## CWWTPR DCO Examination

## Submission by Save Honey Hill Group

## SHH Response to the Applicant's Responses to Written Representations 8.13 [REP2-038]

Date 22 January 2024

**Figure 3.11 Indicative floor layout showing office space footprint and external dimensions in line with App Doc Ref 4.10.1.**

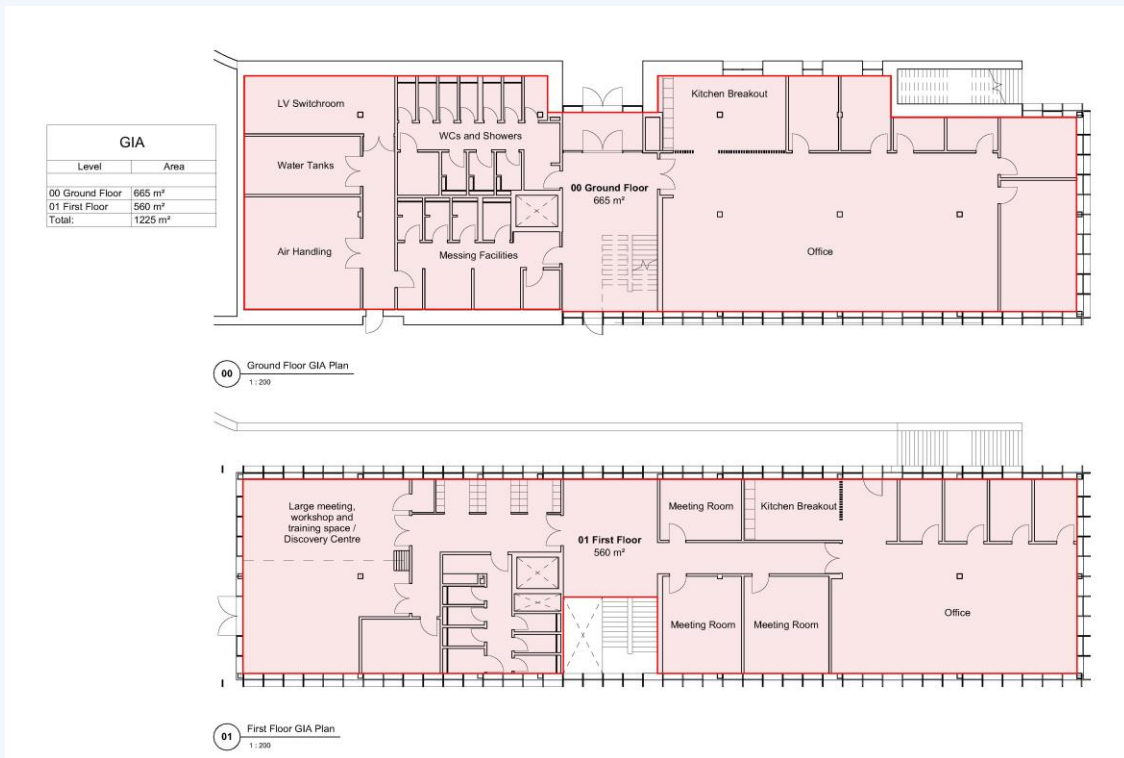
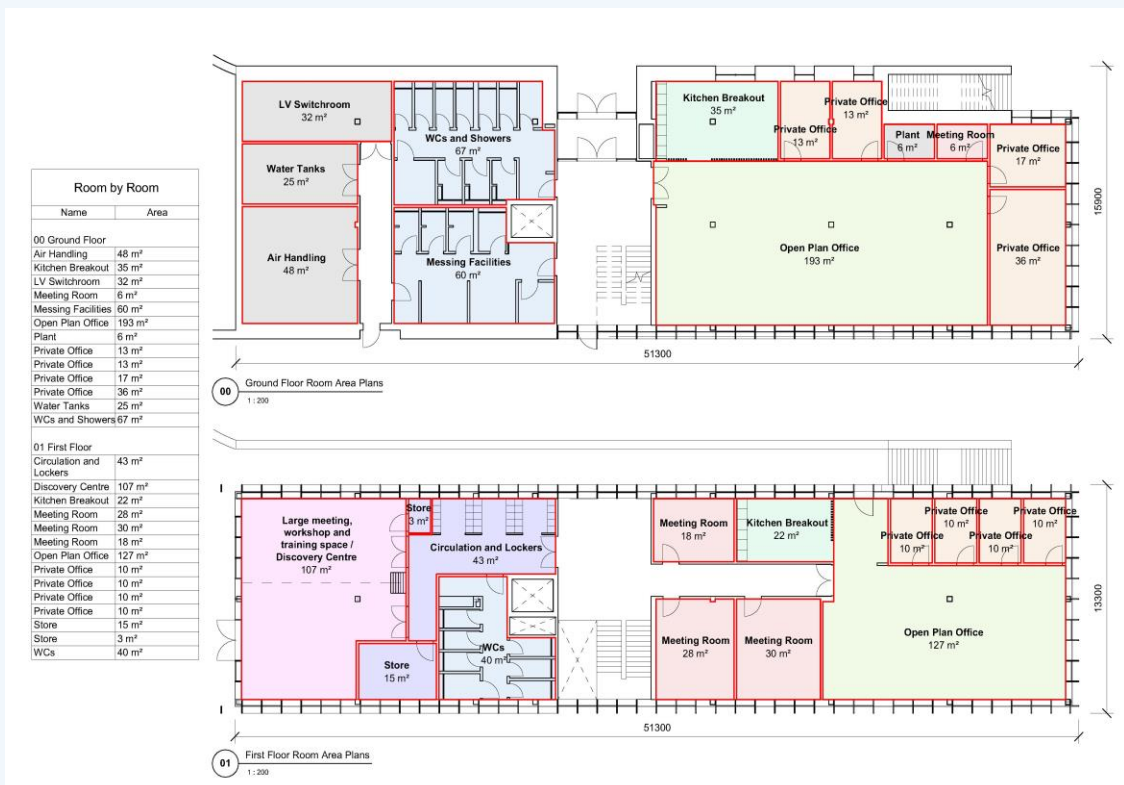
Table 1-23 gives incorrect dimensions for Gateway building and workshop as against dDCO. Former is then corrected in 1.9.11, but latter not corrected in 1.9.14. Now appears to be an error in dDCO and workshop is to be 55m x 16m.
